ASSESSMENT REPORT:

***State Significant Development Application
Block 4 South, Central Park, Chippendale (former
Carlton United Brewery)***

(SSD 5700-2012)

Director General's
Environmental Assessment Report
Section 79C of the
Environmental Planning and Assessment Act 1979

Figure 1 – Separation distances between block 4N and 4S

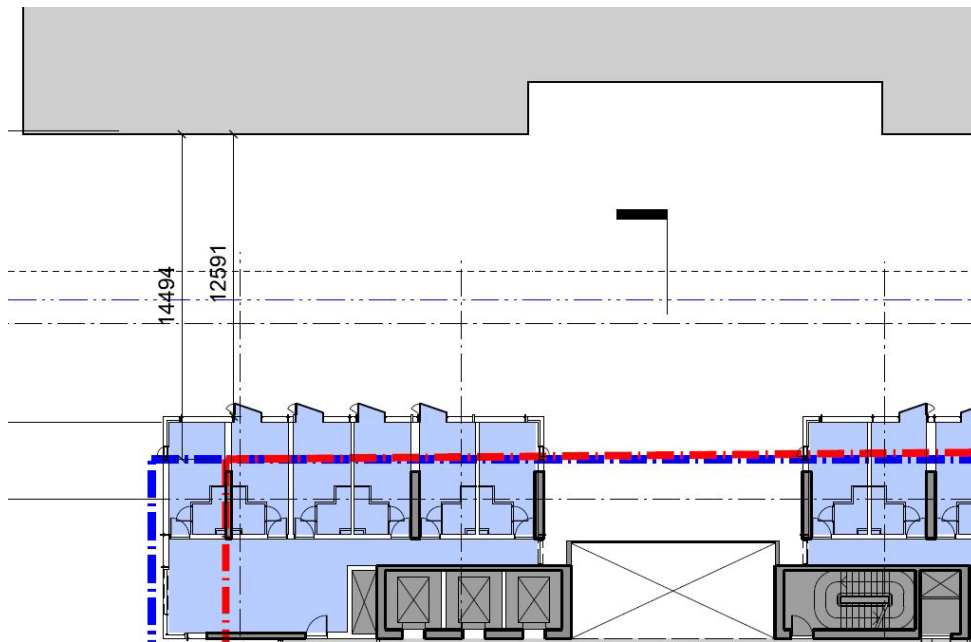
- Council supports an increased building separation between Buildings 4N and 4S to comply with the approved building envelopes. The increased separation will improve amenity for future occupants of Building 4S, reduce building bulk and enhance the public domain;
- Council reiterates its requirement that washing and drying facilities be provided in accordance with Sydney DCP 2012;
- Council supports the provision of additional lifts to service the total number of rooms and occupants proposed; and
- Council comments that maximising the visual permeability of the Abercrombie Street to Central Park pedestrian link is necessary to the useability of the pedestrian link.

Figure 8 – Irving Street Activation with retail.

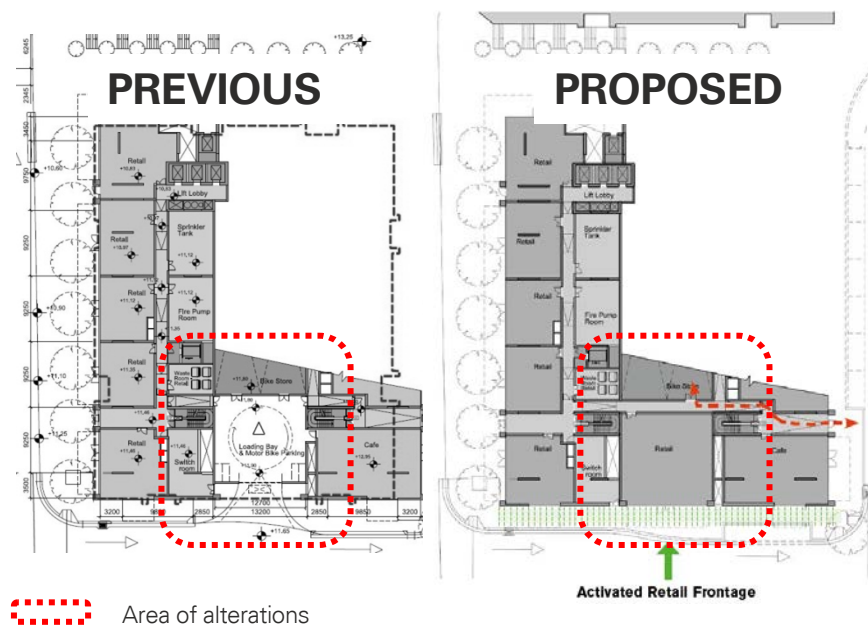
- Upon cessation of the temporary bicycle access and loading bay at Irving Street, this should be converted to retail/commercial uses to activate Irving Street and shall be the subject of a separate development application;
